**NON-MATERIAL AMENDMENT APPLICATION RELATING TO APPLICATION REFERENCE 19/00924/FUL, FOR THE UPGRADE OF EXISTING TELECOMMUNICATIONS APPARATUS AT BRICKYARD PLANTATION, PALE LANE, ELVETHAM, HOOK, HAMPSHIRE, RG27 8AZ (NGR E: 478895, N: 155670)**

This non-material amendment application is submitted in relation to the upgrade of the existing telecommunications site located at the Brickyard Plantation, off Pale Lane, which was granted planning permission under LPA reference 19/00924/FUL.

Title: **265 MAX CONFIGURATION ELEVATION**

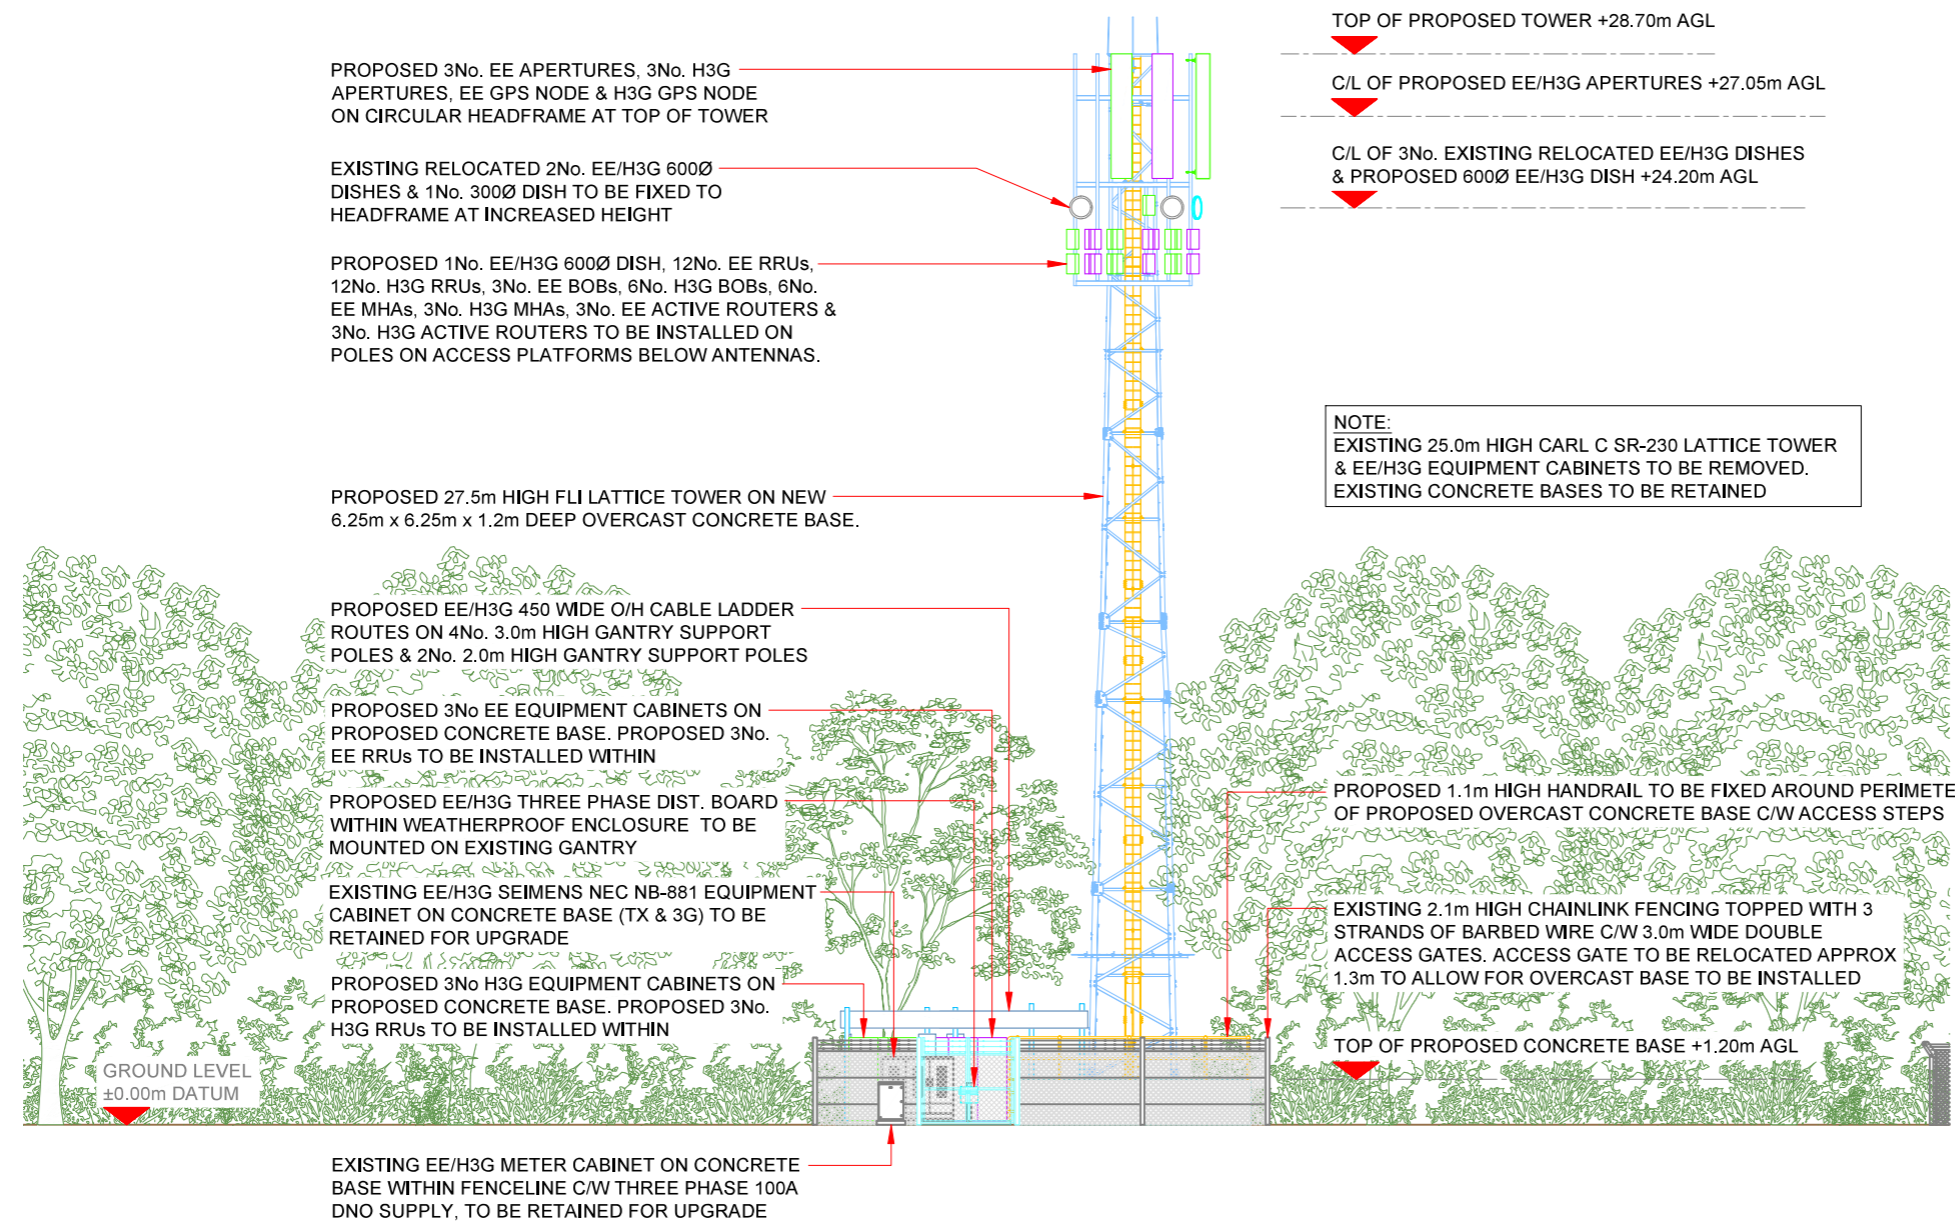
- Height of proposed replacement tower reduced to 28.7 metres (approved height 30 metres);
- Slight relocation of proposed replacement tower, to be located approximately 5 metres to the south of the approved location within the existing established compound;
- Reconfiguration of proposed equipment cabinets, which will now all be located on the existing concrete base to the north of the existing established compound.
